## **Deadline 5 submissions**

Following the visit, I would like to respond to various assertions made by SPR in its submissions in relation to High House Farm. I would then like to identify various other matters of a broader significance.

Plate A25.5.2 Predicted Noise Levels East Anglia ONE North

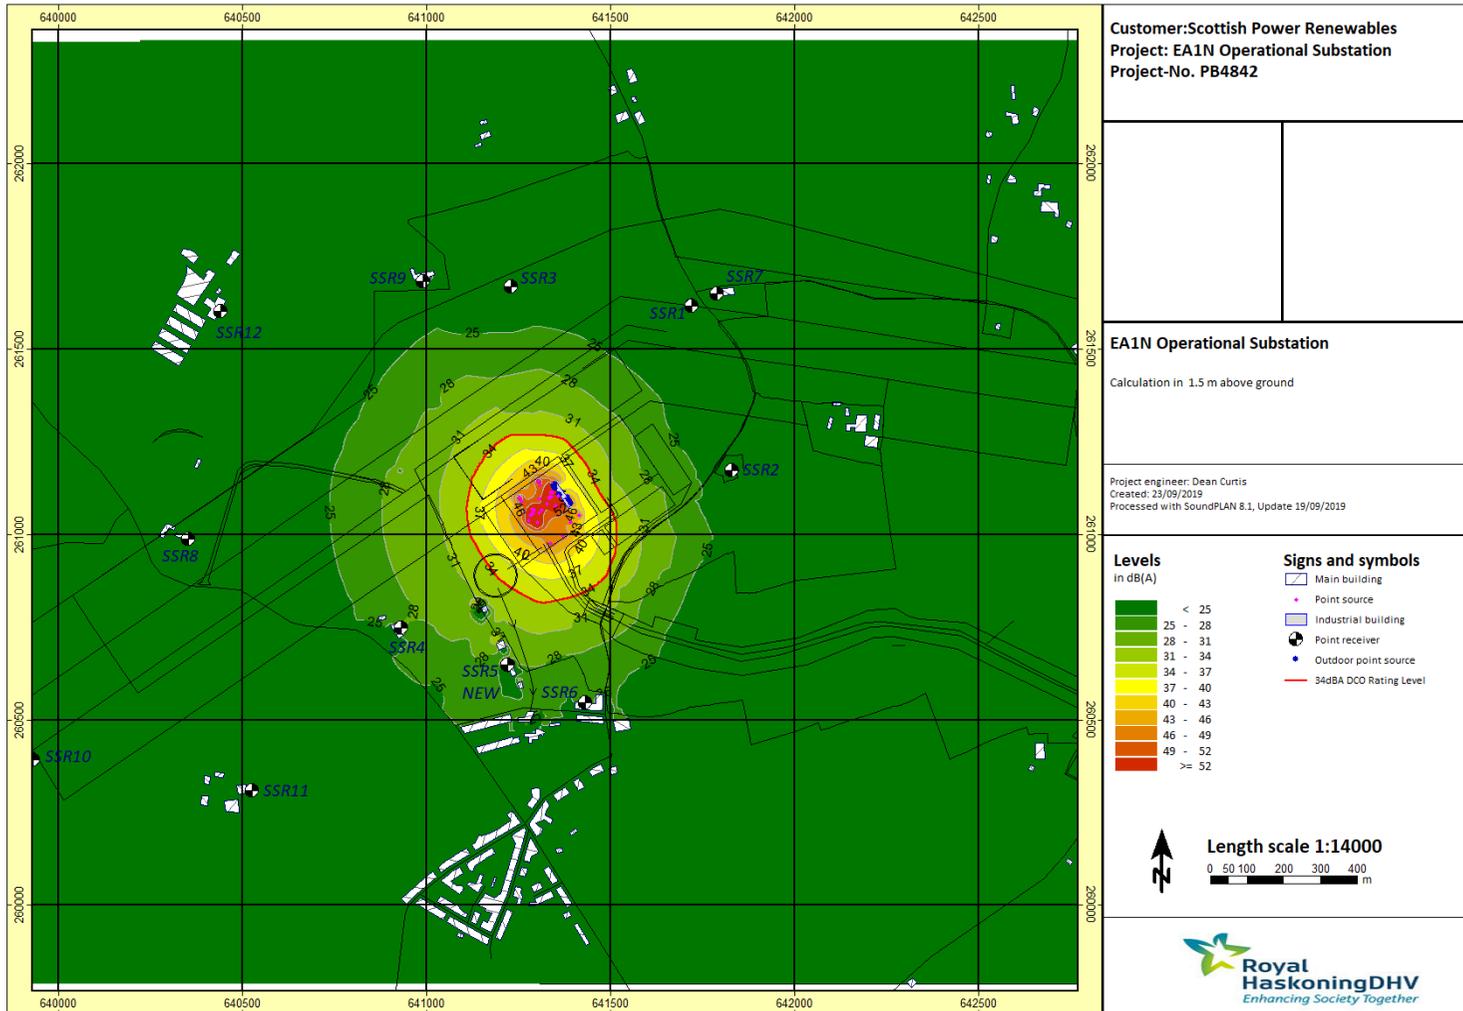
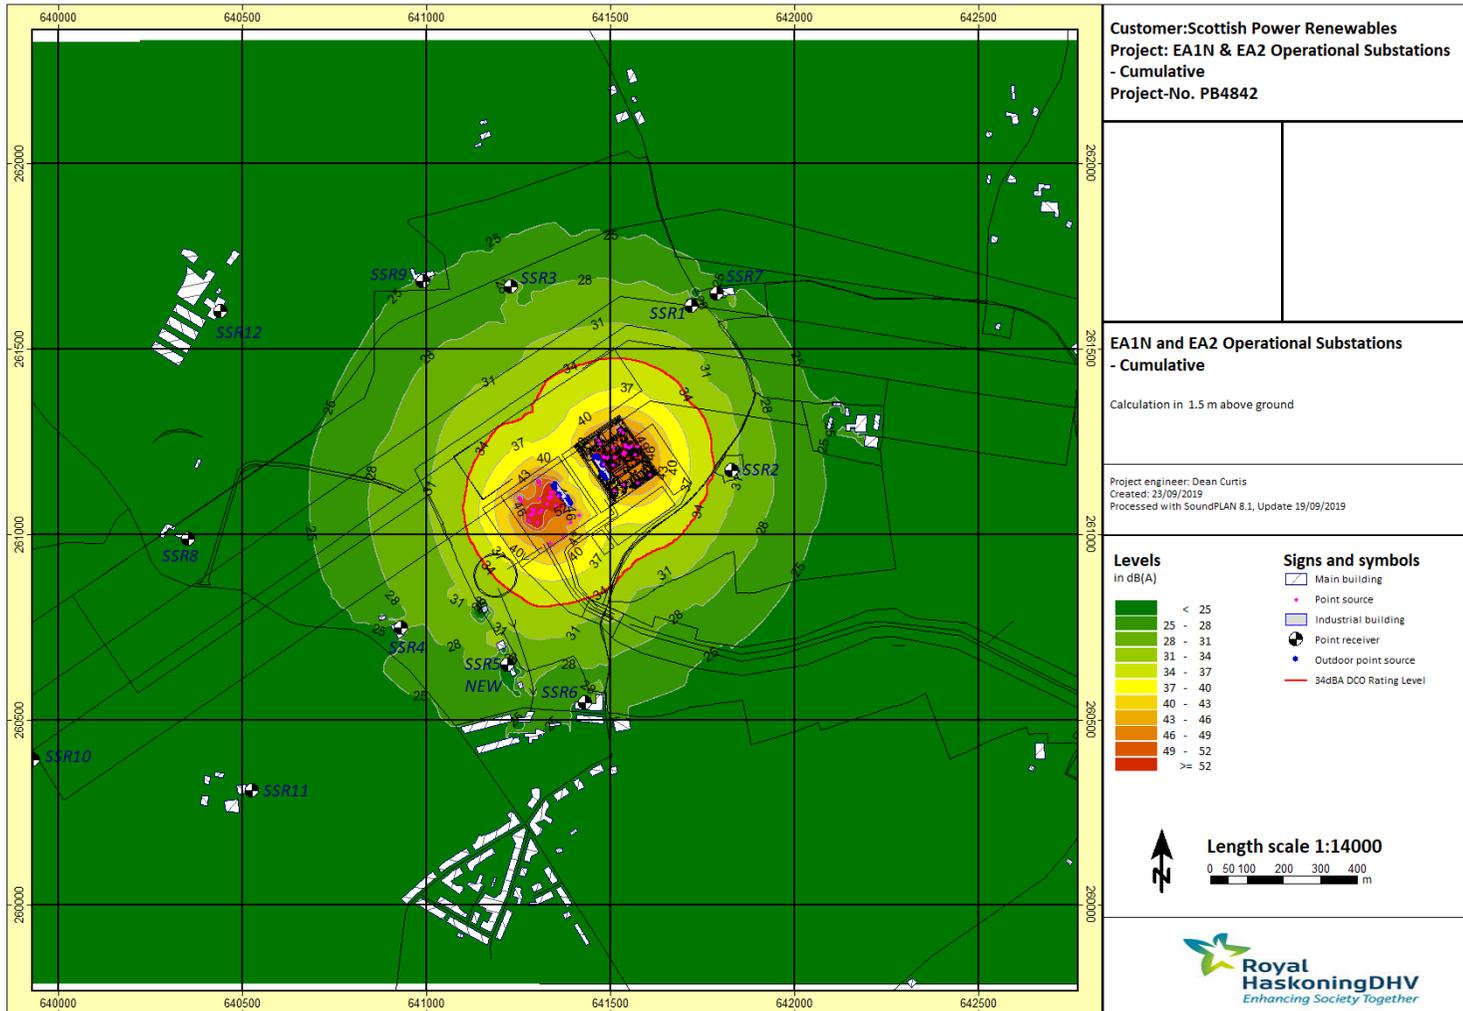
16. **Noise -lack of cumulative assessment in application relating to NG infrastructure:**  
[REDACTED] expert report for SASES makes clear that SPR has significantly underestimated the noise impact of the substations both during construction and during operation. In addition, SPR has not carried out any assessment of any noise that may be made by the NGET installations. SPRs case is based upon assertion only, which is not evidence.

“7.14 No cumulative assessment is provided that includes the adjacent National Grid Substation on the grounds that (ES Chapter 25 25.3.2.1 page 8) “29. The National Grid infrastructure does not contain plant such as high voltage transformers or shunt reactors, or rotating plant such as transformer coolers, that would usually be the dominant noise sources from a substation during operation. 30. Any noise during the operational phase from National Grid infrastructure would be due to switchgear (circuit breakers & isolators), and if present, auxiliary plant such as control systems or an emergency generator.

7.15 However, the subsequent paragraph draws attention to “noise from switchgear which is impulsive in character” but makes no numerical assessment of it on the grounds that “these items of plant are designed to be inherently quiet in operation, and do not make operational noise or vibration at a level that would be perceptible at NSRs.” Impulsivity attracts an additional penalty of from +3 to +9 dBA in BS4142 depending on its perceptibility”

Outline Landscape Mitigation Plan

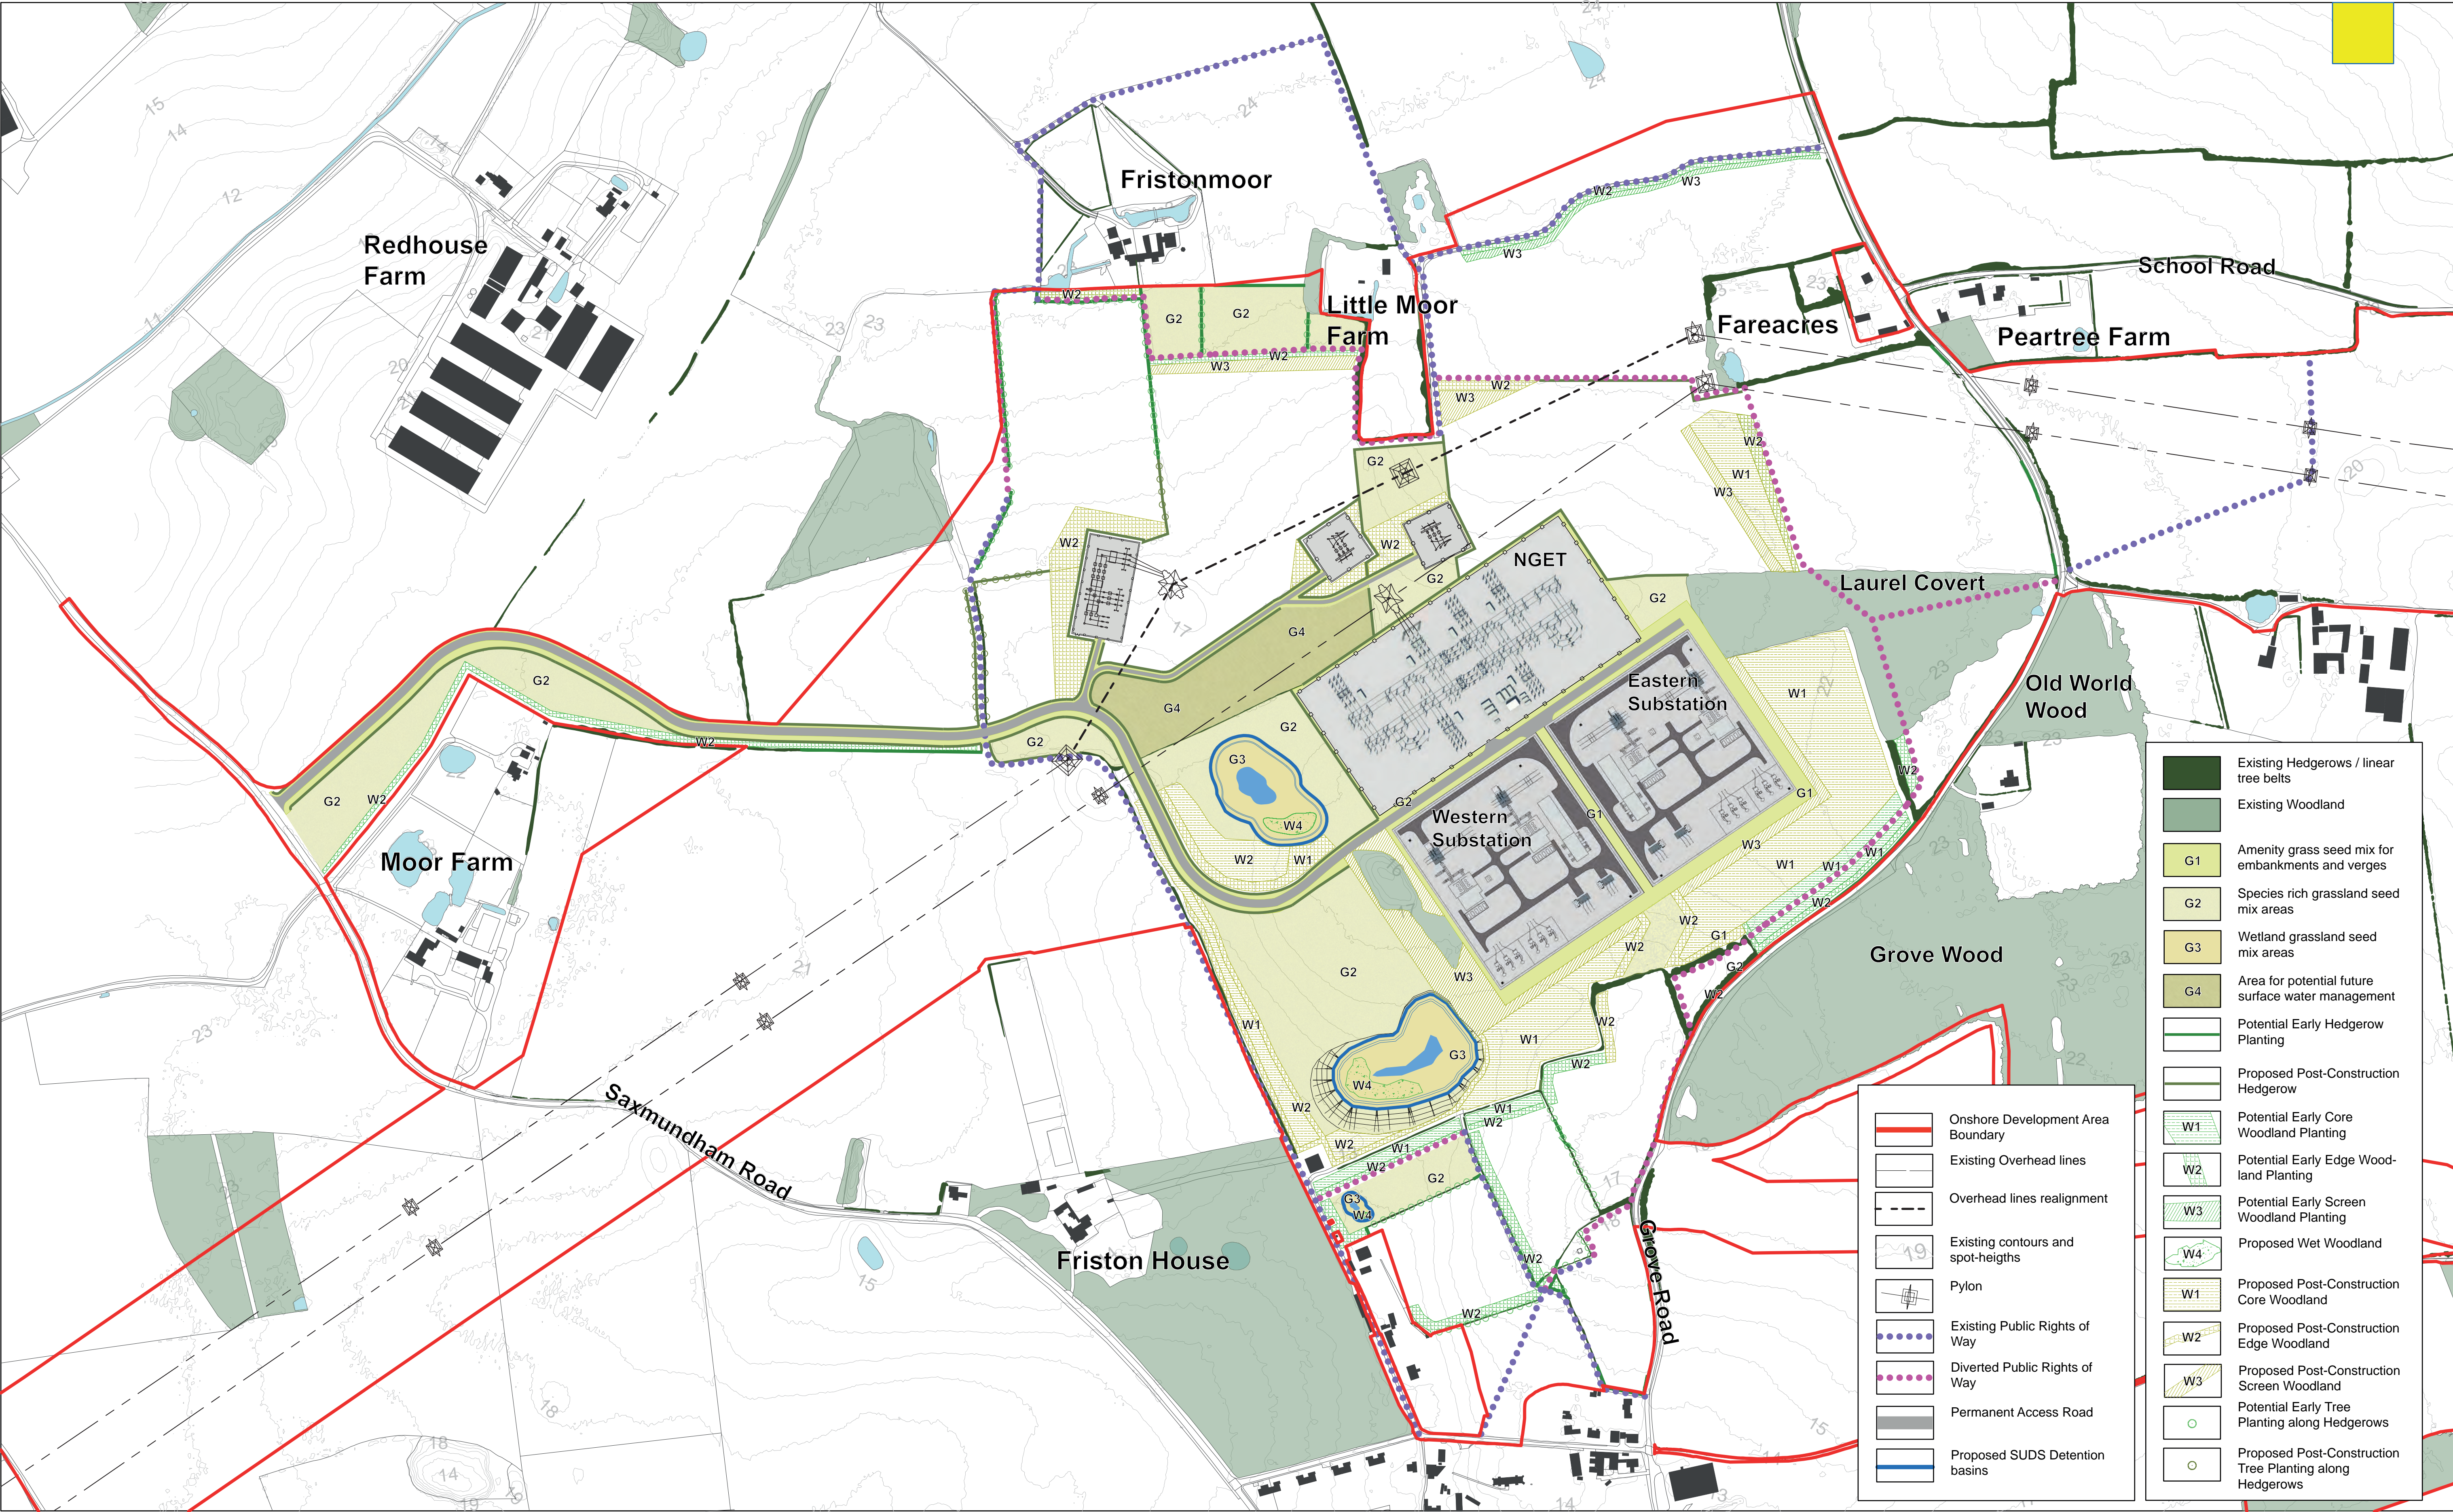
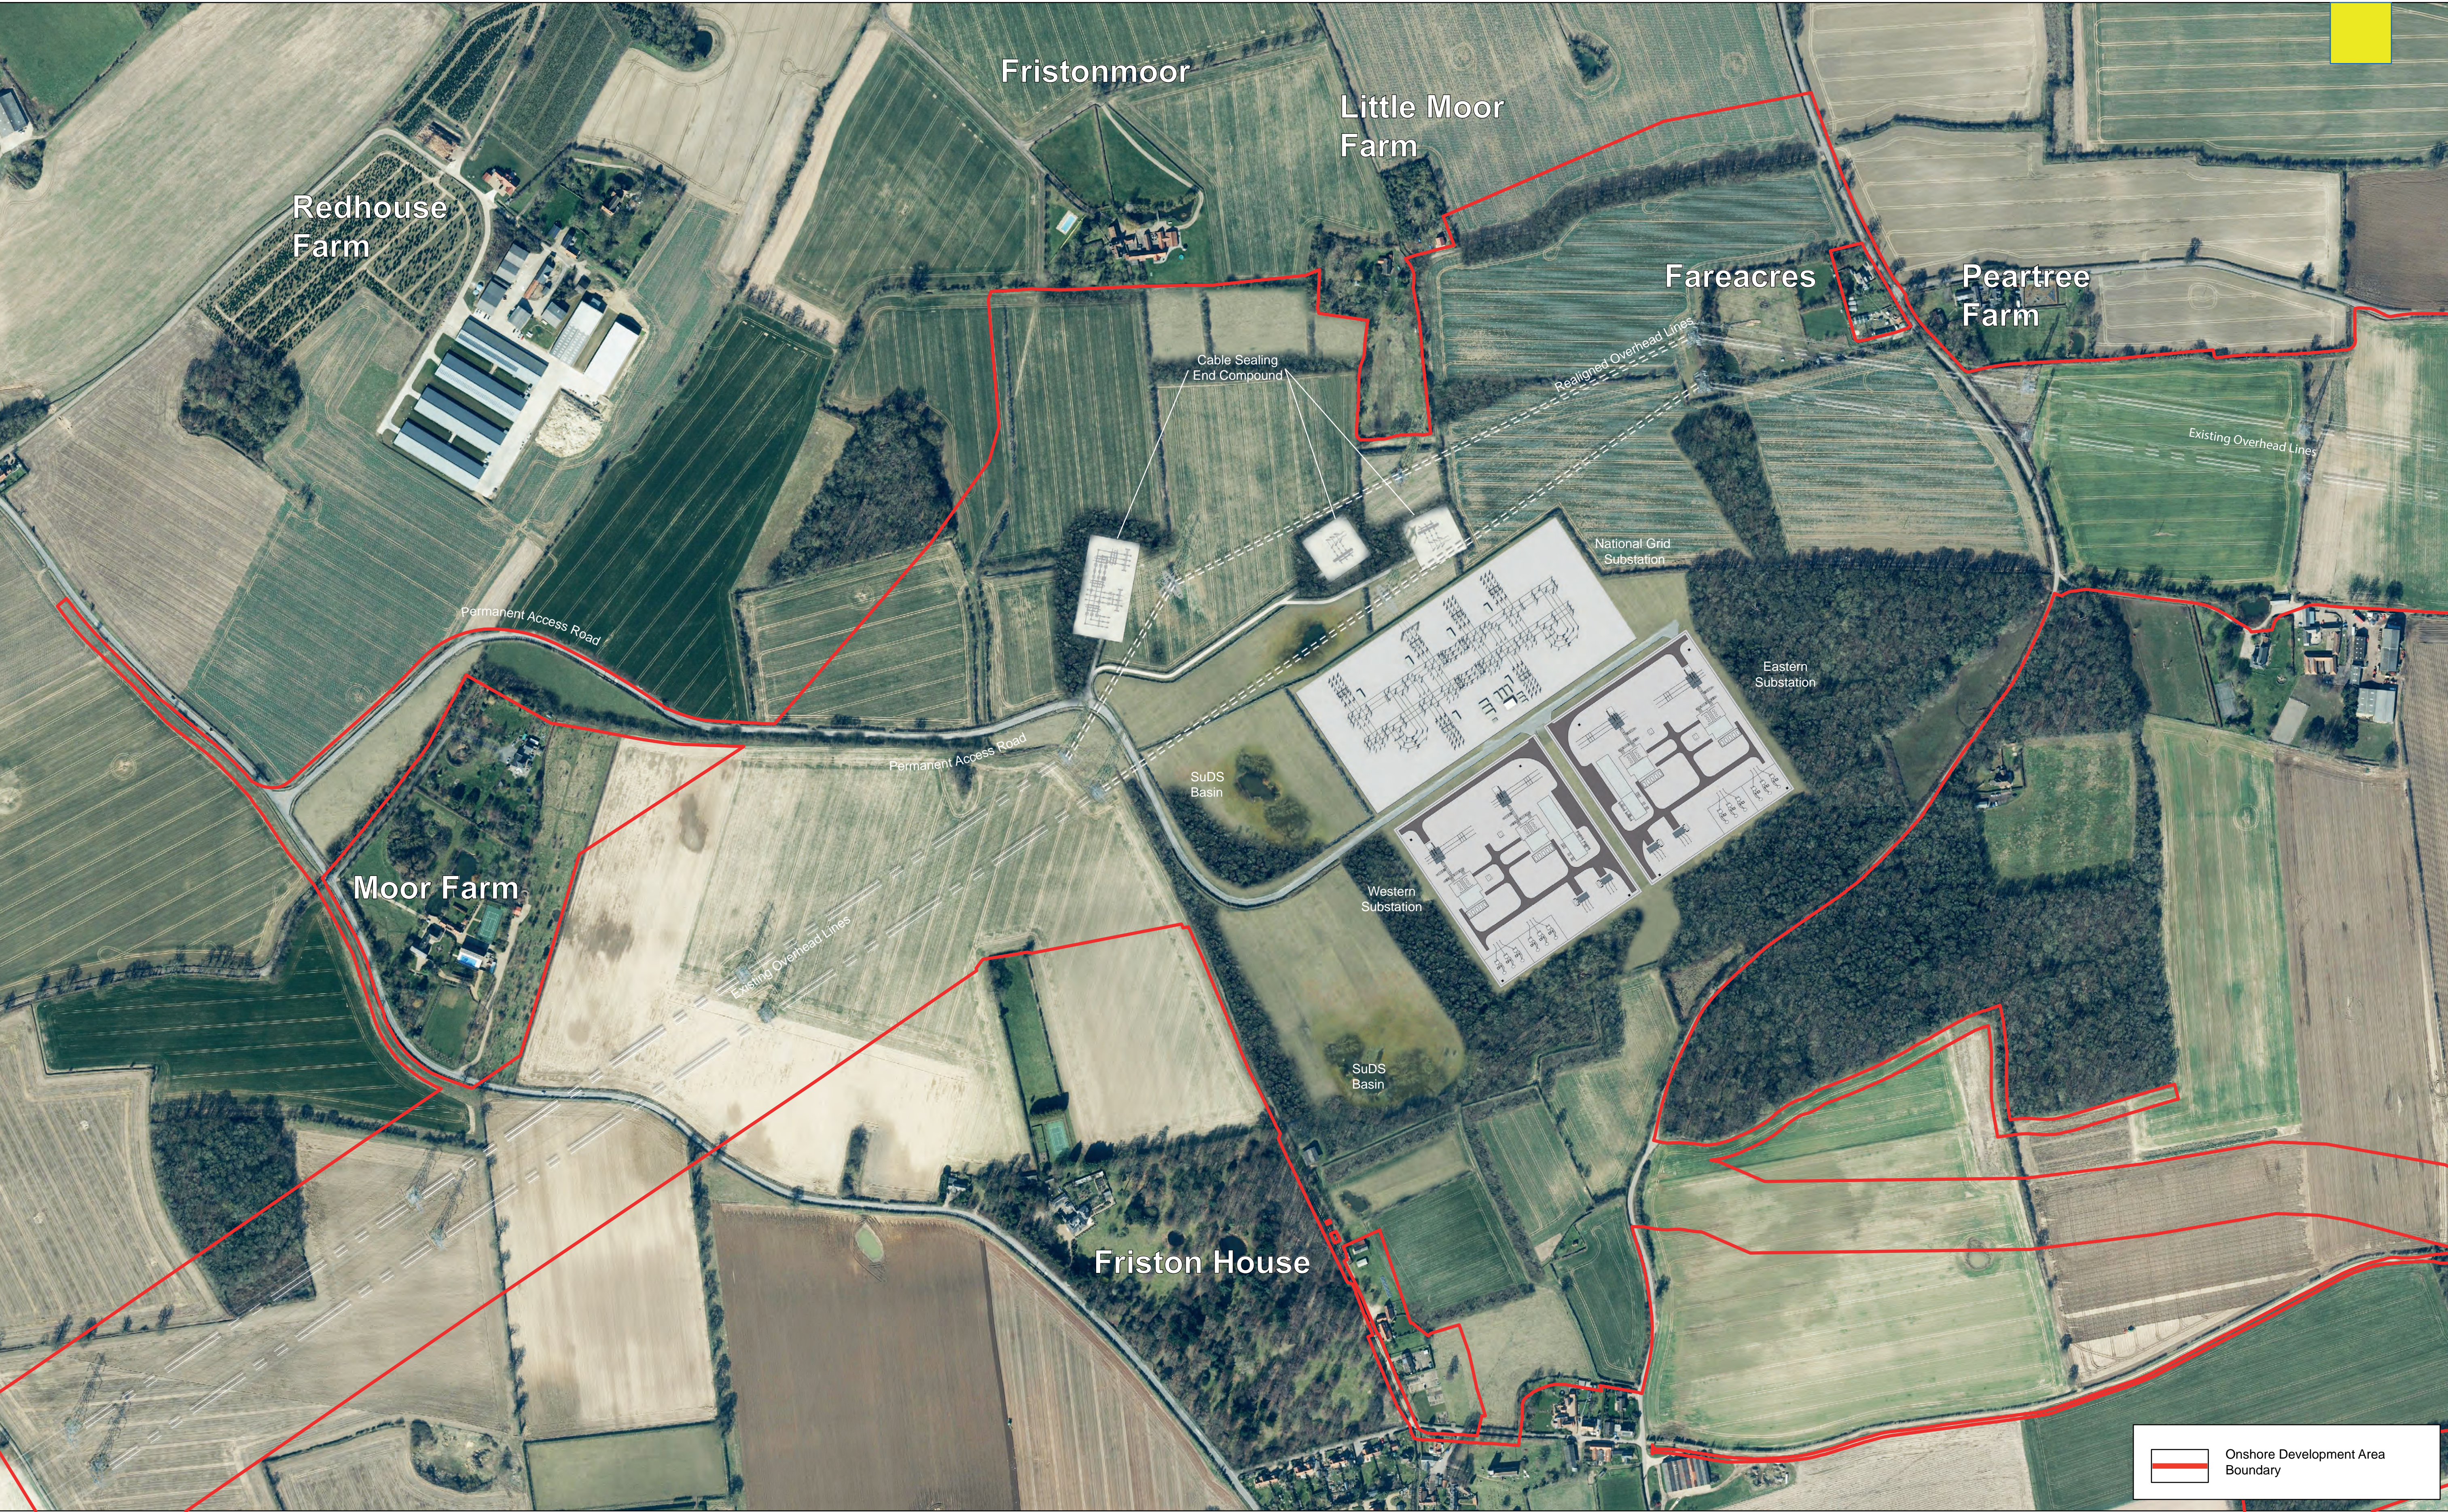
8. The recently published OLMP shows the mitigation proposed by SPR . It consists of a thin section of “potential early edge woodland planting” on our boundary and a thin margin of additional edge woodland planting around the cable sealing end compounds. Because of the proximity to overhead lines the height of the canopy will need to be limited. The LVIA VP5 montages show the proposed mitigation at 1 year into operation and 15 years. Even with the optimistic growth predictions and questionable choice of plants and trees the Cable sealing compounds and compounds are still highly visible and will be from all stories of our home.
